SEPA Environmental Checklist
Mercer Island Center for the Arts

Attachment R
Citizen Question Index

March 2017

MICA SEPA PUBLIC QUESTION/COMMENT INDEX

Figure

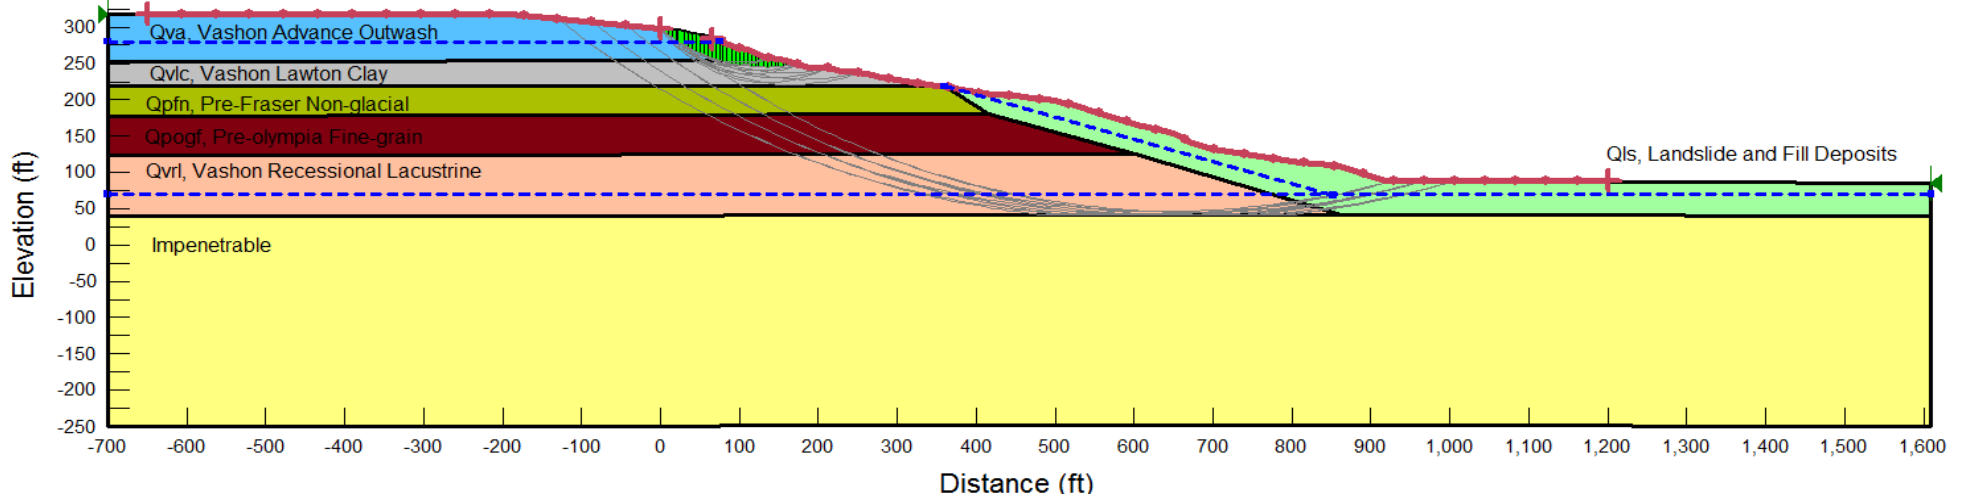
Section	Comment #	Commenter	Comment (paraphrase)
B.0	25	Fletcher	How does a large building in the park "protect the natural environment"?
B.1.1	3	Antilla	Is the Mercerdale location safe from landslide?
B.1.1	27	Fletcher	Multiple concerns regarding parking quantity, location and access
B.1.1	35	Fletcher	Who is responsible for doing the study (including the hillside)? Developer, City or MICA?
B.1.1	36	Fletcher	Was the Environmental Study done before vegetation removal? is the hill at risk of landslide?
B.1.1	59	Granbois	The SEPA Checklist § B, Q. 1 subsection a is non responsive. The "steep slopes" box is not checked even though "excavation into the hillside" will be required. See SEPA Attachment D.
B.1.1	93	Lippert, Meg	Is MICA on a steel slope? What would happen in the event of a landslide - would lives be in danger?
B.1.1	94	Lippert, Meg	"Could erosion occur as a result of clearing, construction or use?" The response includes clearing and construction but not use. Yet erosion from the adjacent hillside could certainly occur during use of the facility, perhaps causing hazardous conditions for occupants

B.1.1	106	Thompson	The geotechnical report should address the risk to patrons of MICA should a slide occur.
B.1.1	142	CCMIP	Add existing information about landslide hazard areas
B.1.1	144	CCMIP	Develop a landscape design that restores and keep the hillside from sliding on structure
B.1.2	61	Granbois	The SEPA Checklist § B, Q. 1 subsection f is non responsive. The question whether erosion could occur "as a result of clearing, construction or use" has not been answered.
B.1.2	143	CCMIP	Add existing information about erosion hazard areas
B.1.3	37	Fletcher	Will the building be able to withstand a 9.0 earthquake?
B.1.3	141	CCMIP	Add existing information about Seismic Hazard Areas
B.10.1	107	Thompson	MICA will have negative aesthetic impacts to recreational users, adjacent land owners, and citizens in general.
B.10.2	38	Fletcher	How will MICA impact views at the park and for neighbors?
B.10.2	67	Granbois	The SEPA Checklist § B, Q. 10 subsection b states "building itself will not alter or obstruct any views". In fact, the MICA building will obstruct views of the wetlands and natural hillside.

Figure 1
Parking Location and Pedestrian Pathway Study

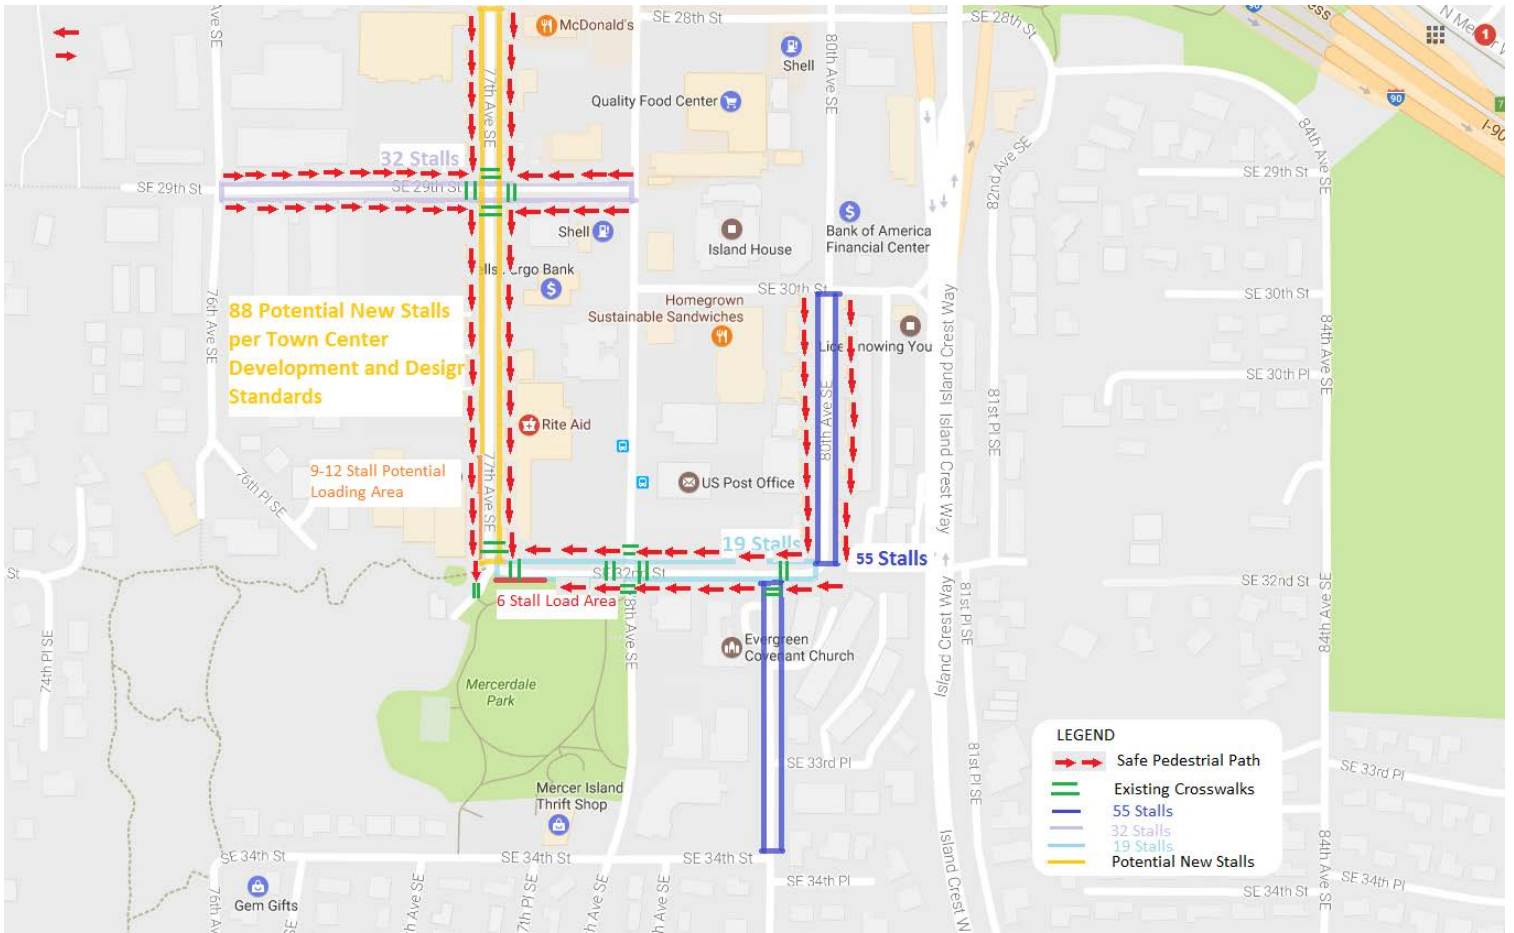
B.14.3	12	Jeff Bender	New Seasons will affect on-street parking supply
B.14.3	13	Jeff Bender	MICA needs a Transportation Management Plan to get MICA users to its facility in modes other than single occupancy vehicles.
B.14.3	14	Jeff Bender	On street parking should not be counted
B.14.3	24	Fletcher	How can adding more parking and adding cars help attain our quality of life?
B.14.3	45	Fletcher	The Code talks about "off-street parking," but in the Application, you are talking about "off-site parking," is there a difference between off-site and off-street?
B.14.3	75	Granbois	Attachment G (#2) to the SEPA Environmental Checklist proposes parking that fails to acknowledge let alone comply with MICC 19.05.010(D) and MICC 19.05.020(B)(4).

Section	Comment #	Commenter	Comment (paraphrase)
B.14.3	108	Thompson	I object to MICA's parking management plan that proposed to eliminate any requirement for off-street (on-site) parking.
B.14.3	138	Morrison	Parking.
B.14.3	163	CCMIP	On street parking should not be counted
B.14.4	15	Jeff Bender	Off street parking should have 30 year agreement
B.14.4	19	Fletcher	Did anyone check with Thrift Shop, Rite Aid, Farmer's, City and Metro for patrons to park in their lots?
B.14.4	52	Fletcher	Have anyone submitted any parking agreements with private land owners to evidence its "off-site" parking, which should be a requirement for any SEPA review.
B.14.4	55	Fletcher	Is there a parking agreement with other property owners?
B.14.4	70	Granbois	The correct answer to "how many parking spaces would the completed project have" is ZERO.
B.14.4	109	Thompson	MICA has not presented any informal or formal agreements with private property owners for parking for MICA, including the Farmer's property or the Rite-Aid property.

B.14.4	136	Chong	Concern that MICA patrons will be parking in Lower Mercerdale neighborhood.
B.14.4	162	CCMIP	MICA provides no evidence that it has engaged with nearby private owners for parking.
B.14.5	46	Fletcher	Where are they going to be dropping the children off?
B.14.5	51	Fletcher	if the parking is across the road in the Rite Aid parking lot or on the street across the road from the proposed MICA, how does one propose patrons are supposed to get to the parking in a safe manner?
B.14.5	73	Granbois	Where specifically will the "queued vehicles" be other than in the street? There is no drop off area – how will the "staff outside" assist with cars lined up in the street?
B.14.6	47	Fletcher	How are the refuse trucks supposed to get to the back of the building to pick the trash up from?
B.15	74	Granbois	There is no answer to whether "the project resulted in an increased number of public services". In fact, neither the Chief of Police nor the Fire Chief have been consulted about whether this project will increase the demand for public services.
